CITY OF ALBUQUERQUE

**RE: Durango at the Trails (File: C09D012), Unit 1
Grading and Drainage plans, Stamp Date 5-20-15**

CITY OF ALBUQUERQUE PUBLIC WORKS DEPARTMENT	
DURANGO UNIT 1 GRADING AND DRAINAGE PLAN			
Design Review Committee	City Engineer Approval	Mo./Day/Yr.	Mo./Day/Yr.
Last Design Update			
City Project No.		Zone Map No.	Sheet
XXXXXX		C-09-Z	1 Of 5

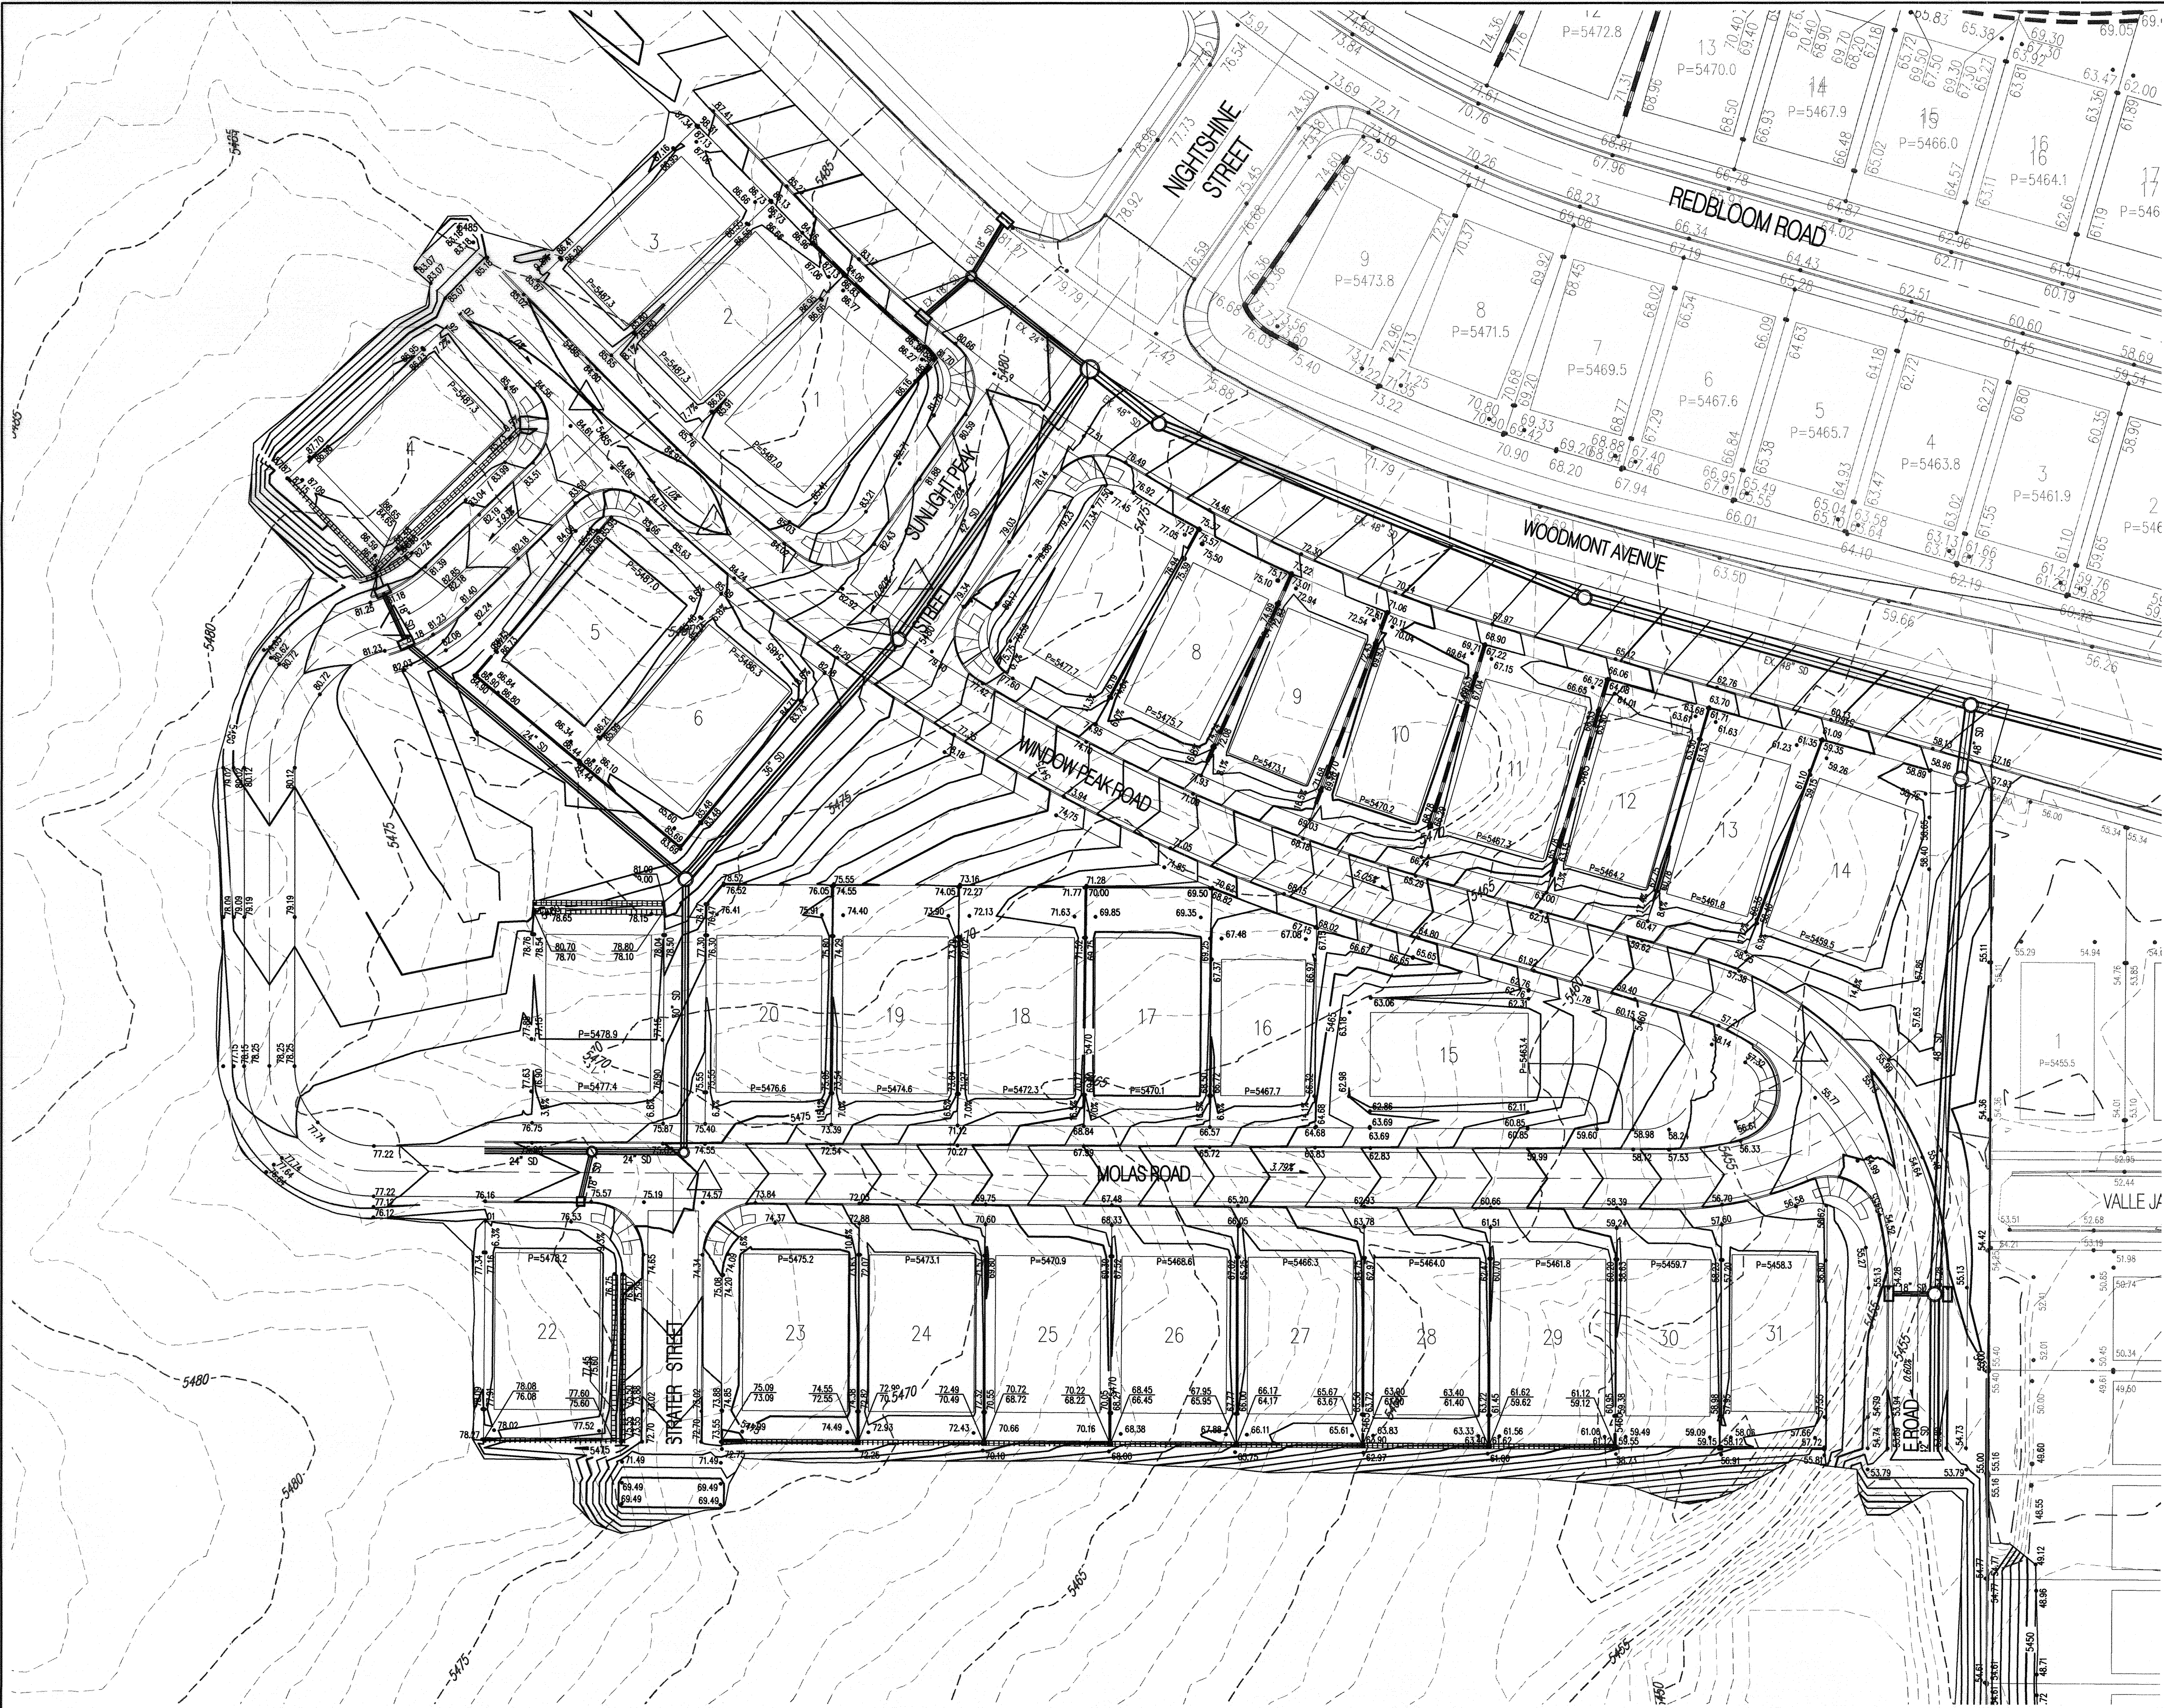
3. Hatch pattern for the double garden walls need to be reflected on the legend
4. Lot 5, Unit 1 – show a garden wall on NW side of lot.
5. Submit Sheet 5 showing a corrected cross-section of the double garden walls, labeled as "TYPICAL TIERED WALL NOMENCLATURE".
6. Revise contours at intersection of Red Mountain and Window Peak so that the high point in front of Lot 1 is reflected.
7. Provide a valley gutter in front of Lot 2 to direct flows to sump in Red Mountain
8. Adjust MH13 so that it ties into SD in Woodmont at 90 deg or less
9. Show existing contour lines of Woodmont Avenue
